**Beaches Yard,
Horton Road,
West Drayton**

**Prepared for
Harvest Land Management**

Reference: 75221/APP/2022/2968

Highways Officer: Joshua O'Donnell

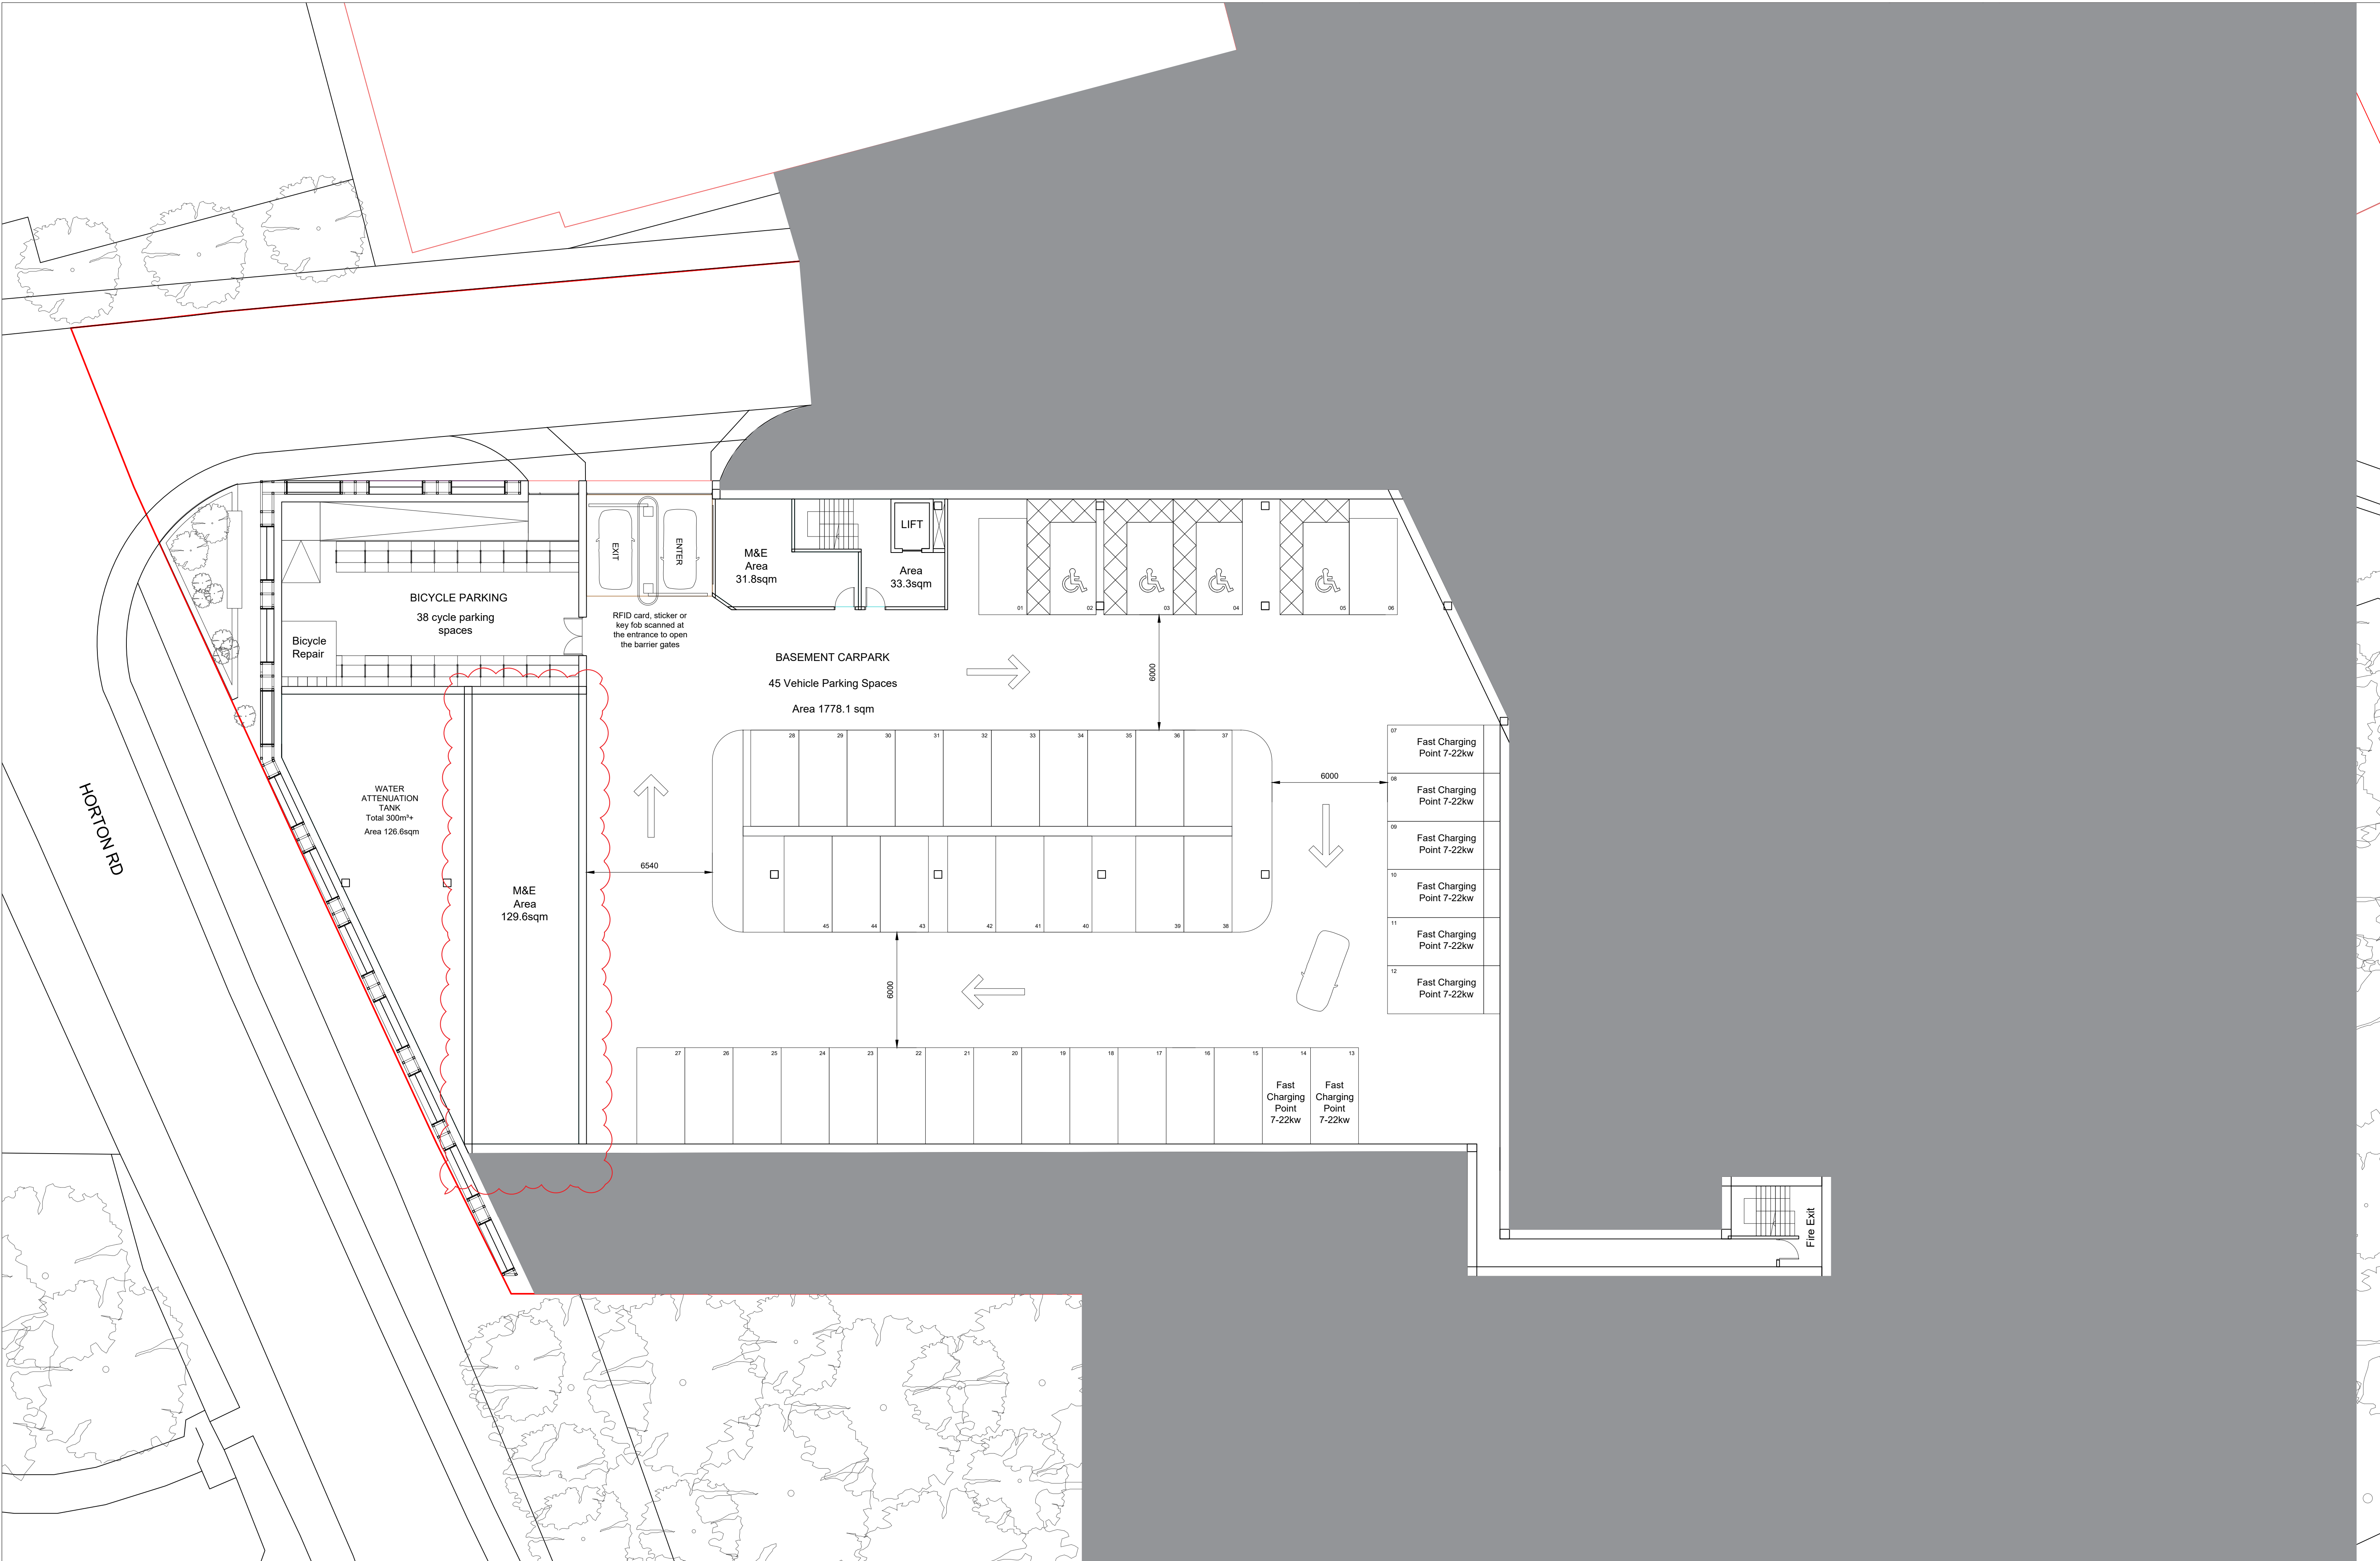
Amended plans now indicate that the private road outside of the development are within the applicant control through the new red boundary line that is seen on plans. It is good to see that some enforcement will be made by preventing cars from parking on the road through the installation of double yellows. Nevertheless, the Highway Authority would require that more improvements be made to the road that would improve road safety and make it more suitable for HGV use. It is noted that the footpath will be widened on the side of the development, though this does not lead anywhere for pedestrians to go. Furthermore, nothing has been proposed to restrict vehicles from exiting both the basement car park and loading bay that ensures that drivers check to approaching vehicles. Finally, the Highway Authority would require that the applicant demonstrate how further improvements can be made to the road which increase road safety. This contradicts the published London Plan 2021 Policy T4 Assessing and mitigating transport impacts which states that *'development proposals should not increase road danger'*.

The Highway Authority would require that all pedestrian access into the basement car park be moved onto Horton Road or internally. This would negate the need for a footpath when the road is already narrow and would mean that pedestrians do not interact with entering/exiting vehicles.

As mentioned above the loading bay will include a vehicle turntable which will rotate the HGVs within the site. There is still the high risk that this can malfunction which will lead to vehicles being unable to turnaround within the development. HGVs should be able to turn on plot without the necessity of machinery, as HGVs are the fundamental use of the site. The Highway Authority will be unable to support any application that see's the implementation of a vehicle turntable. Swept path drawings have been again submitted, though they still indicate that HGVs turning left from Horton Road onto the private road would be very close to the footpath and over sweeping it. This contradicts the published London Plan 2021 Policy T7 Deliveries, servicing and construction which states that development proposal for new consolidation and distribution facilities should *'reduce road danger, noise and emission from freight trips'*.
